Proposed Peartree Hill Solar Farm Order (“Order”)

Deadline 6 (19 December 2025) submission on behalf of Albanwise Limited, Albanwise Synergy Limited, Albanwise Farming Limited, and Field House Renewables Limited, collectively “Albanwise” (IP F04E592CD)

Albanwise’s comments on [REP5A-031]

SHEET 2 OF 17

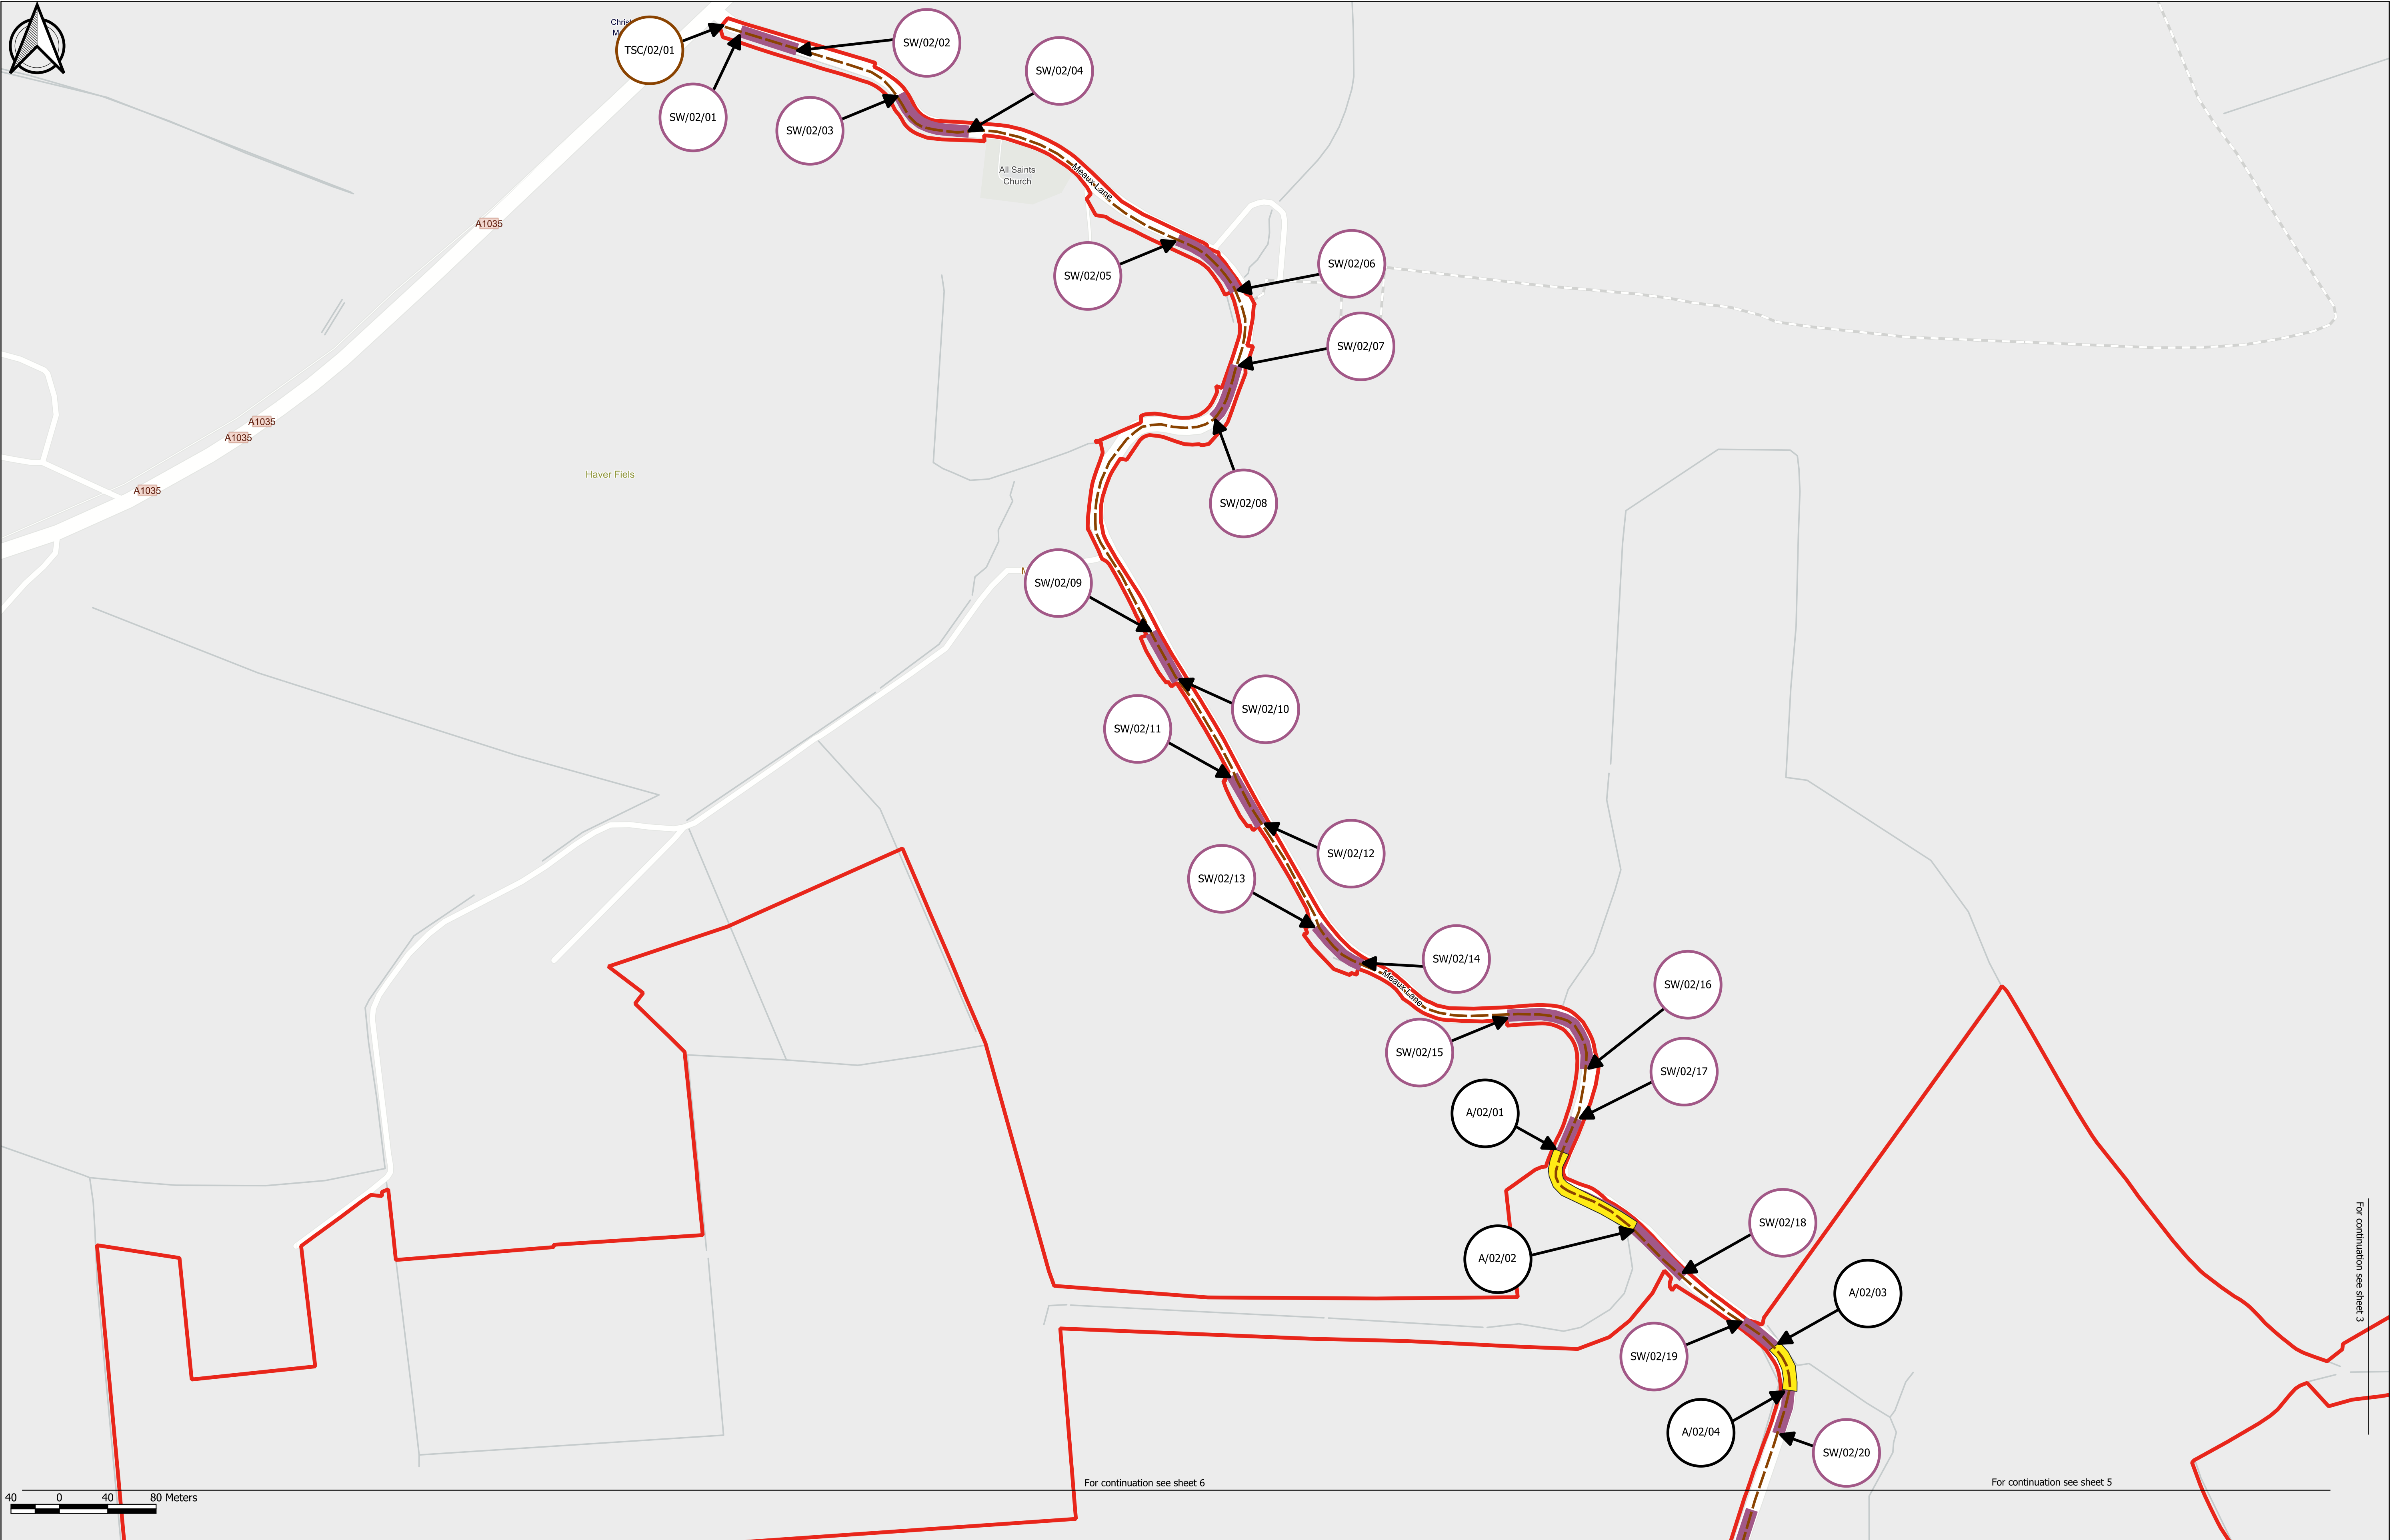
- ***Reduction of the need for associated hedgerow and vegetation clearance between the points marked A/02/01 and A-02/02 on sheet 2 of the Streets, Rights of Way and Access Plans [PDA-005].***

Albanwise response: It is not clear why the provision of an access would require the removal of more than circa 20m of hedgerow at this point. No assessment has been made of the requisite hedgerow removal from the proposed new access track (Change 9) and so no comparative analysis has been made by the Applicant. It would appear that circa 40m of hedgerow would need to be removed where at the southern edge of Field House Solar Farm, Plot 2A-4 and the proposed access track turn 90 degrees to the south east. This hedge is identified in REP4-004 but not marked as being subject to removal, although designs supplied to Albanwise by the Applicant show an overlap with the proposed passing bay. The limited amount of hedgerow removal referred to by the Applicant cannot possibly amount to a compelling case in the public interest, especially when it is not even a negative given the amount of hedgerow that will likely need to be removed to enable Change 9 access to be utilised.
